WEST SUSSEX COUNTY COUNCIL  
PLANNING SERVICES CONSULTATION

SUBJECT: EG/108/17/OUT- Outline application for a 3 bedroom chalet style bungalow.  
Resubmission of EG/89/17/OUT.

10, Downview Road, Barnham, PO22 0EE

Indicative Design

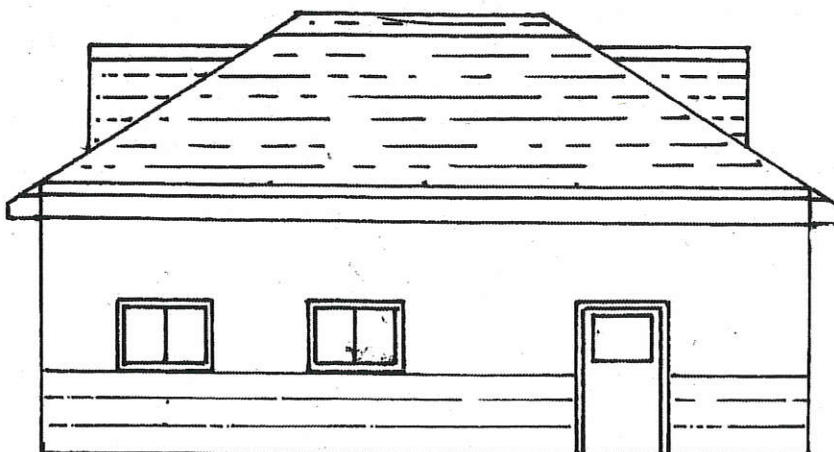
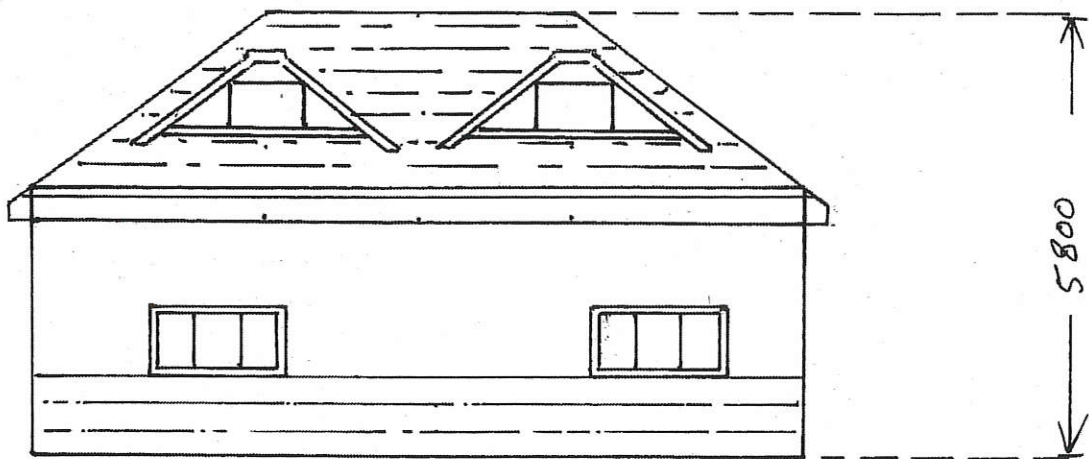
Parking has not been demonstrated, although ample space is available within the site. A minimum of 2 parking spaces would be sufficient for a dwelling of this size in this location and a turn on site would be advisable given the long driveway access route.

Based on guidance given by the WSCC Water and Access manager, emergency vehicles will require a minimum of 2.75m access width to navigate onto the site. This should be considered when constructing the access route.

On the information submitted there would appear to be no grounds to resist this outline application from the highway point of view, details outlining adequate parking and turning should be sought by the LPA alongside any future reserved matters application.
